# CITY OF ALBUQUERQUE

October 28, 2016

RE: **Bella Vista Assisted Living**  
**13101 Constitution NE**  
**Request Permanent C.O. – Accepted**  
**Engineers Stamp Date 5/14/15 (J22D067)**  
**Certification Dated: 10/13/16**

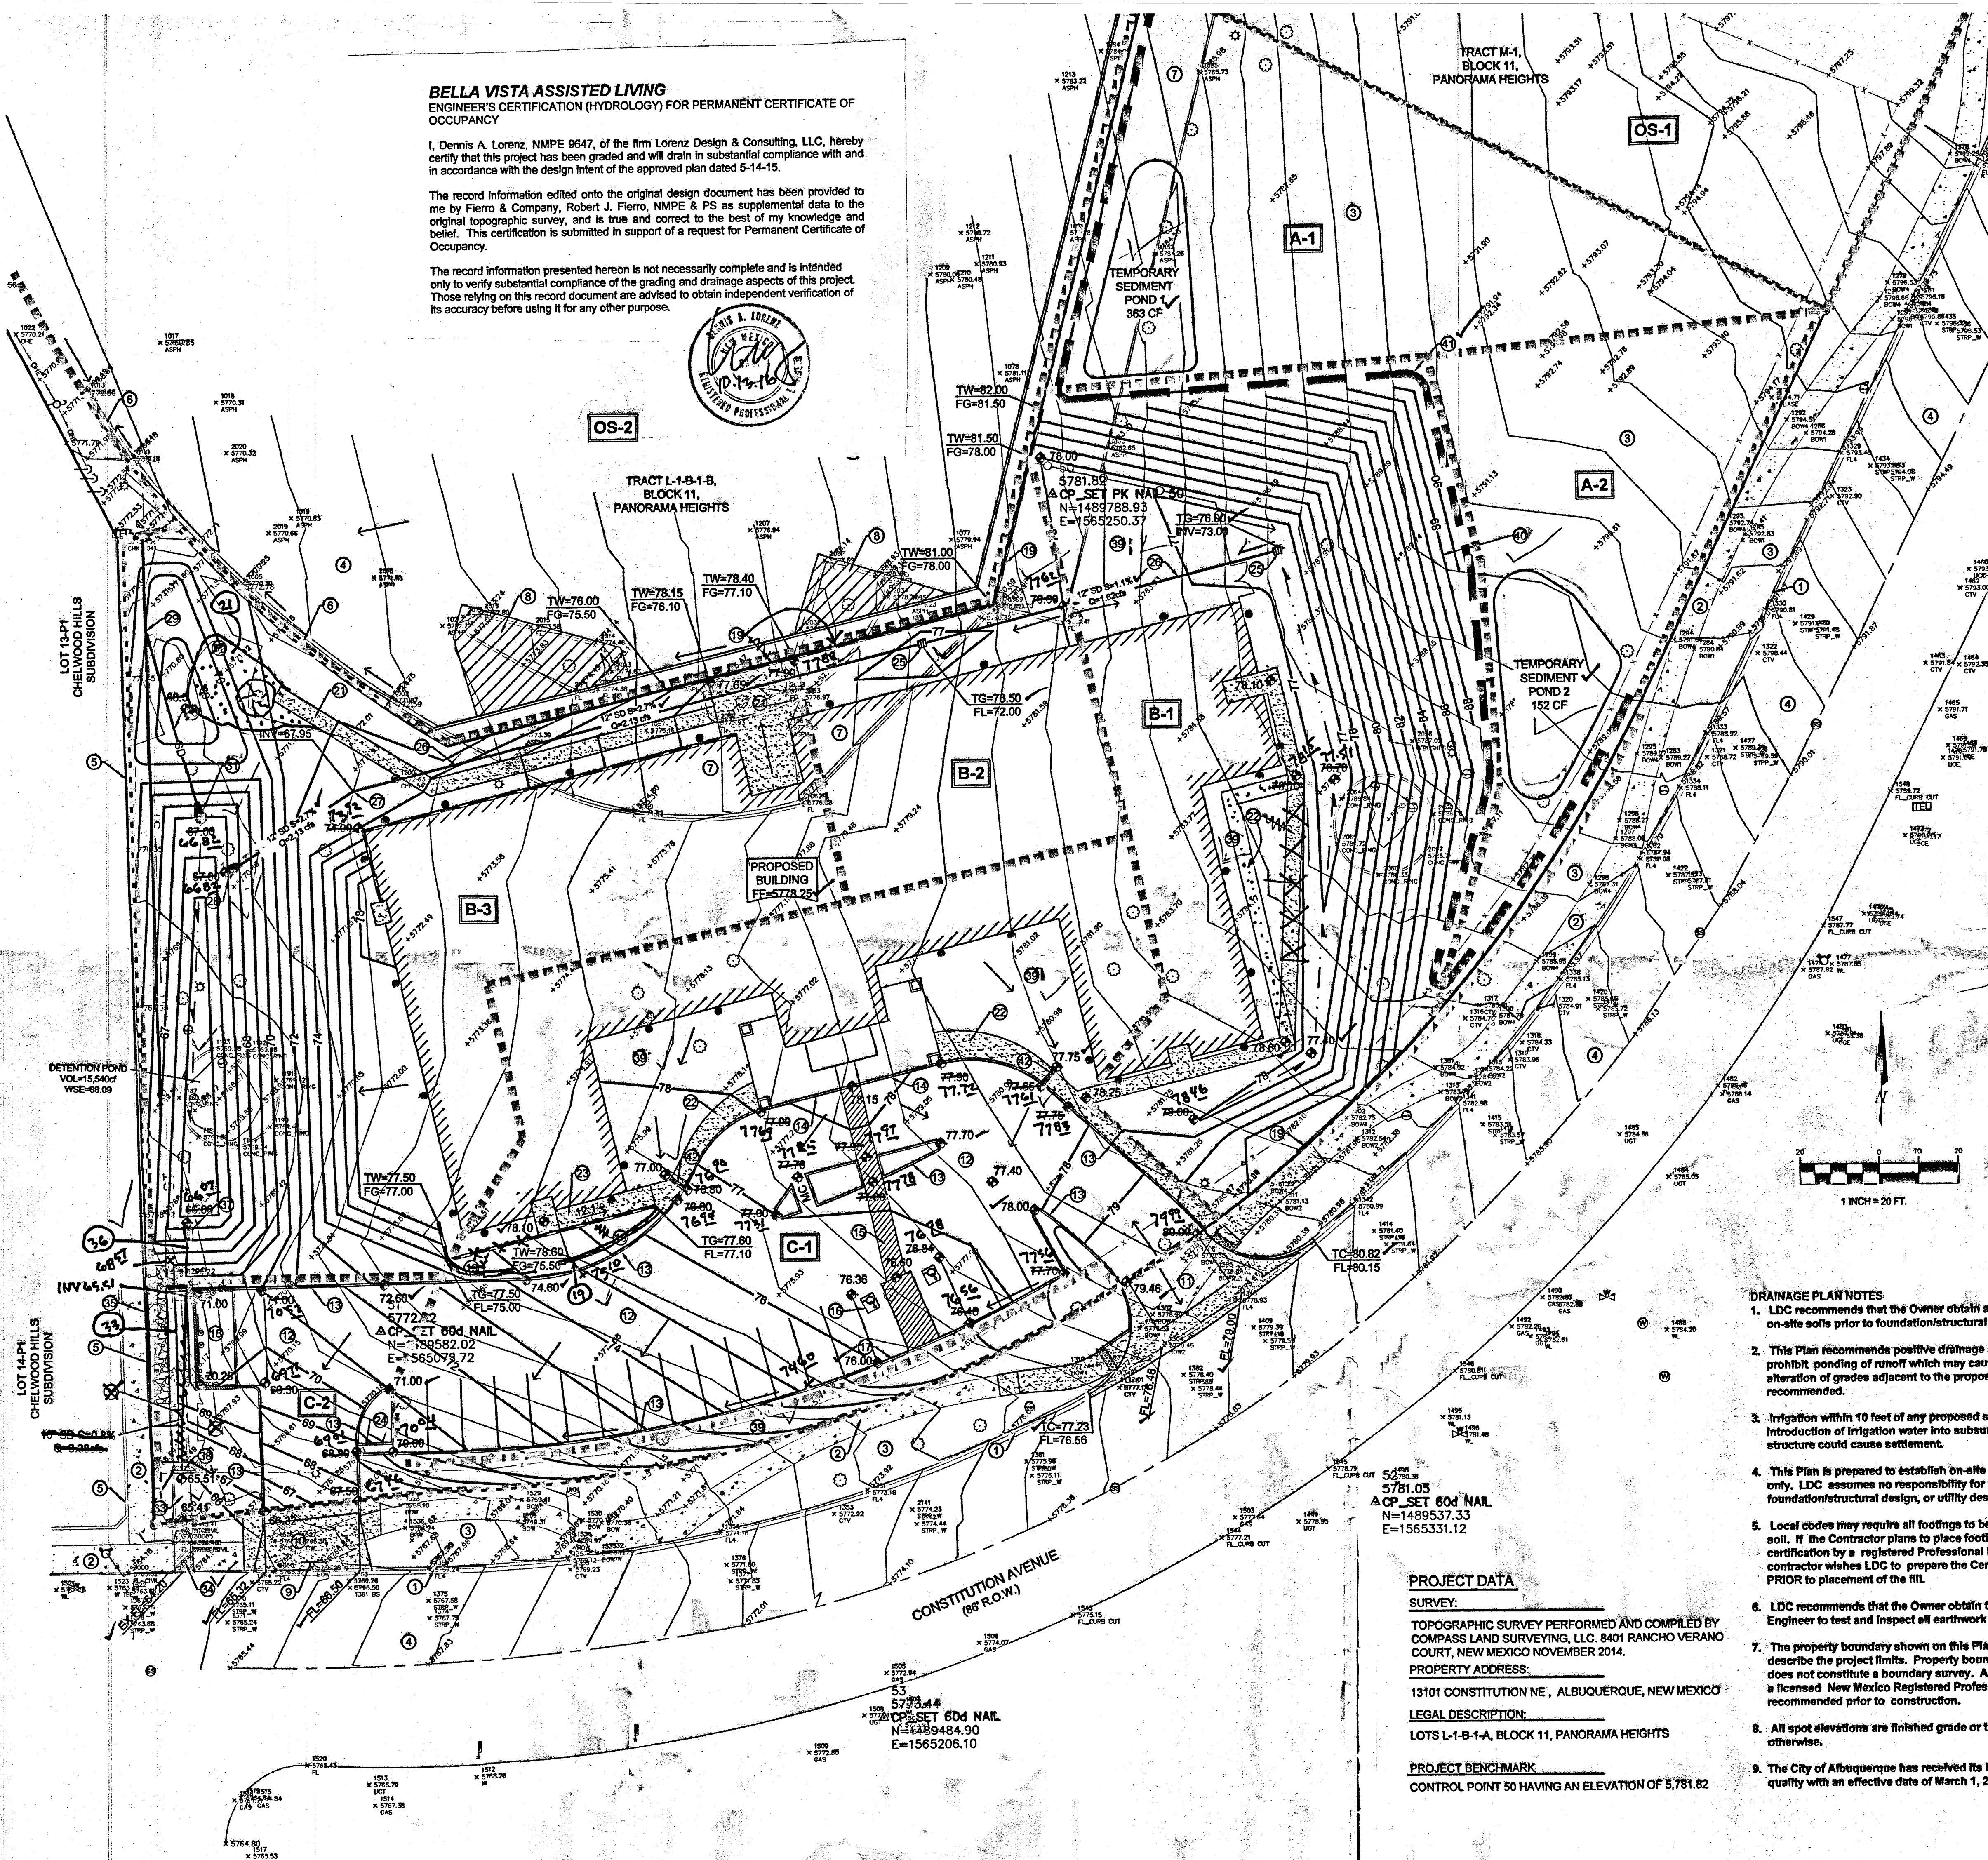
- The owner is to be advised that the splash blocks do not appear to direct the flows on to the sidewalk, but to each side therefore filling the area with water from 5 downspouts between the building and sidewalk. We recommend the owner monitor the drainage on the east side of the facility.
